Application Ref: 21/00265/DPP

| <p>UPRN:000120016423_____</p> <p>(If NO UPRN – Admin to contact Technician)</p> <p><u>Site Address:</u> (<i>Leave blank if no UPRN</i>)</p> <p>98 Eldindean Road Bonnyrigg</p> | <p><u>Description of Proposal:</u></p> <p>Erection of outbuilding</p> |

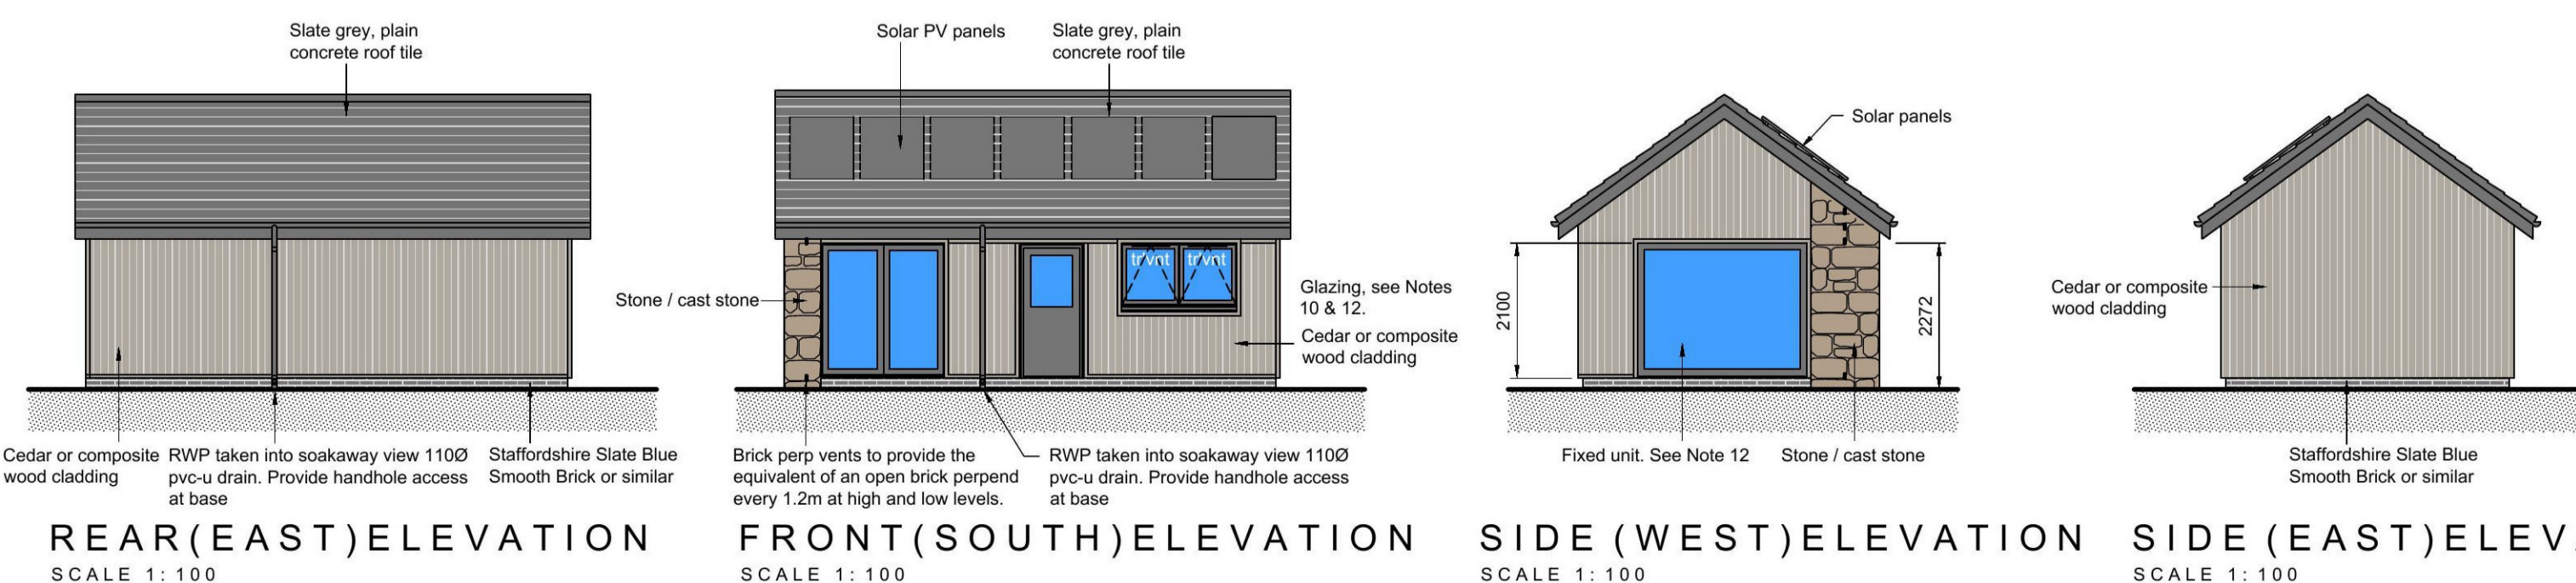
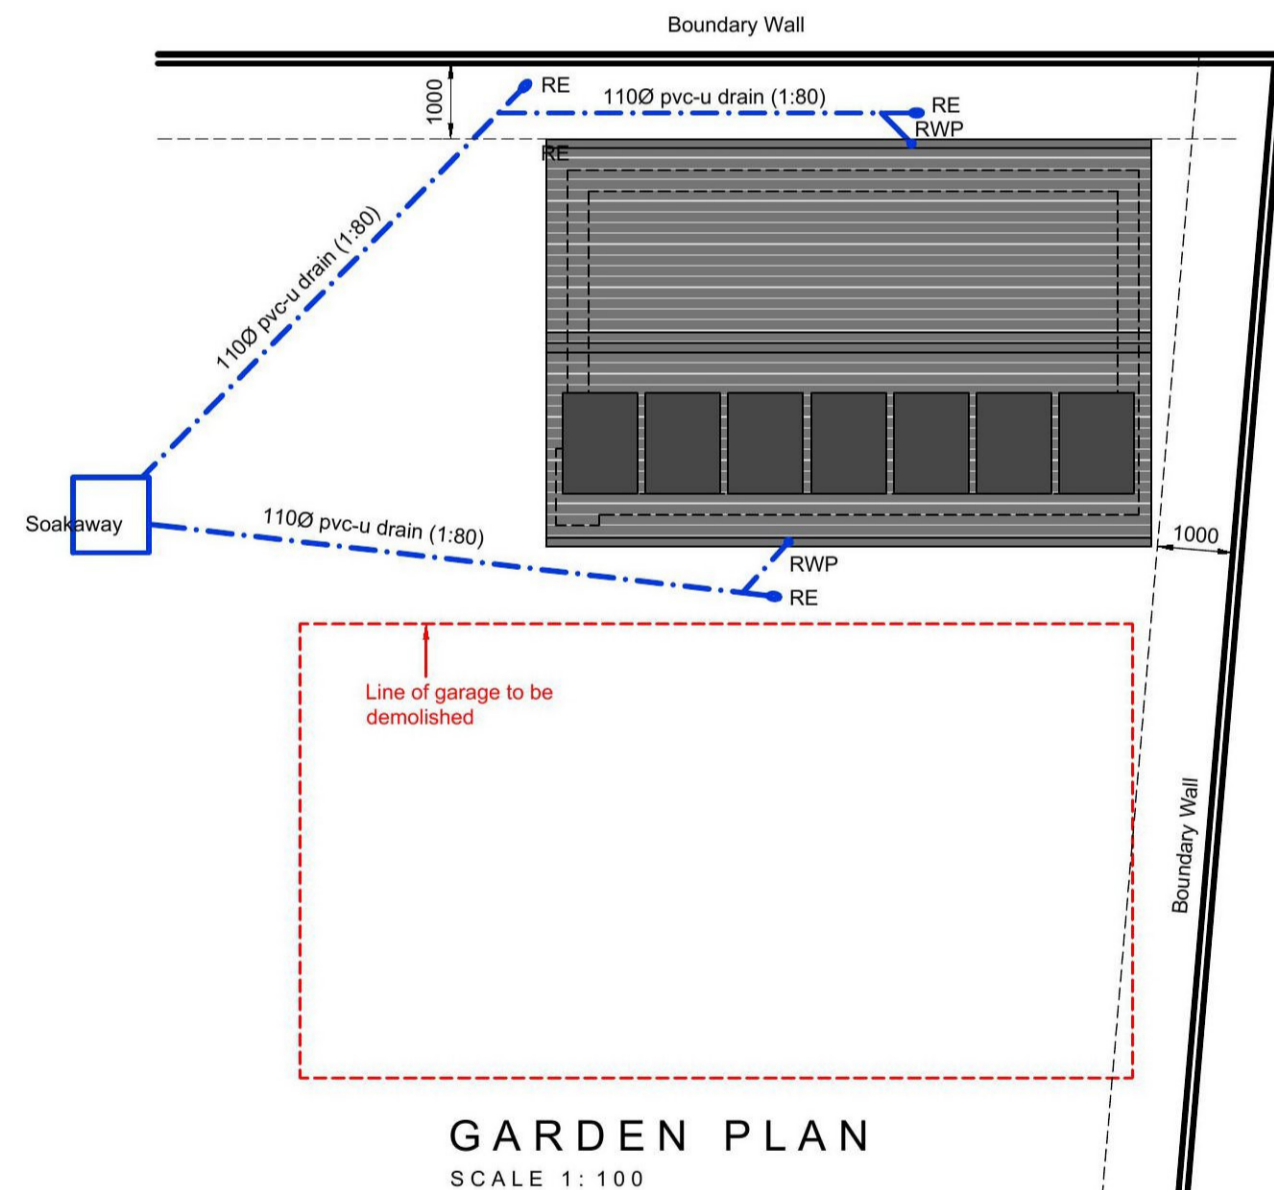
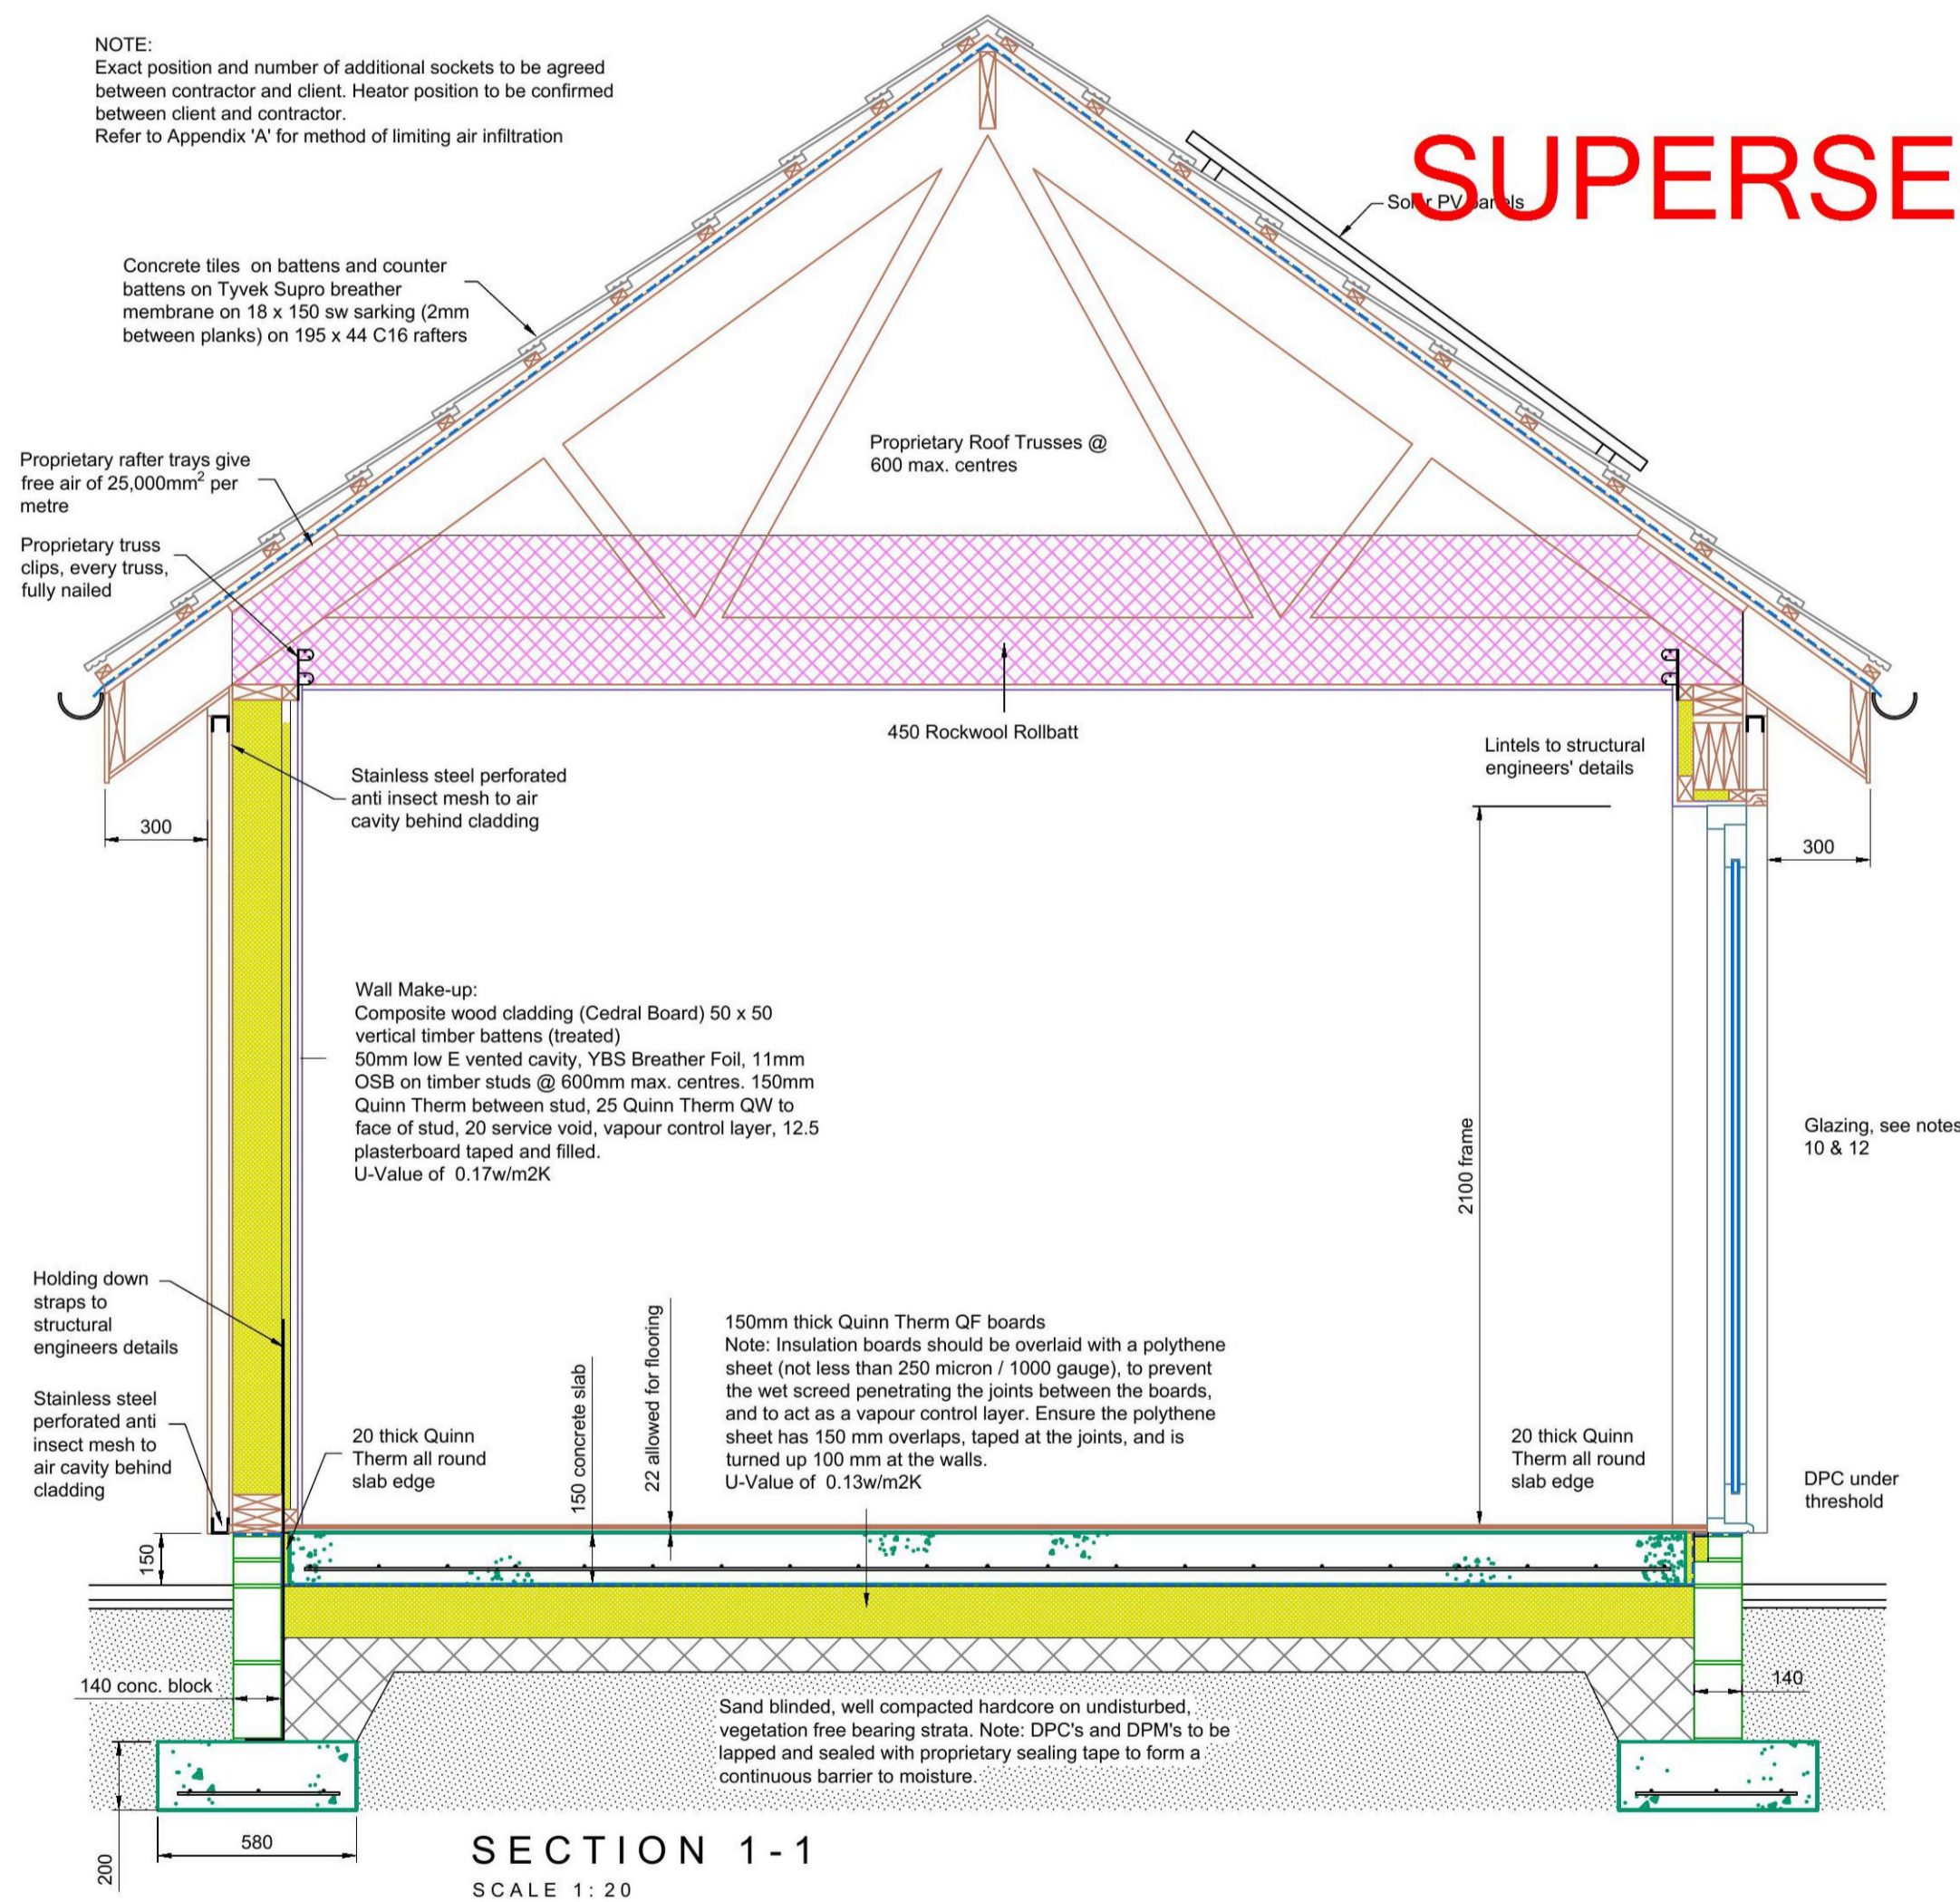
The proposed position of the outbuilding shown on the garden plan on drawing number D590-AS-BW-001 1 does not match the position of the outbuilding shown on the site and location plans. Please amend either the site and location plans or the garden plan to accurately show the position of the outbuilding in relation to the site boundaries.
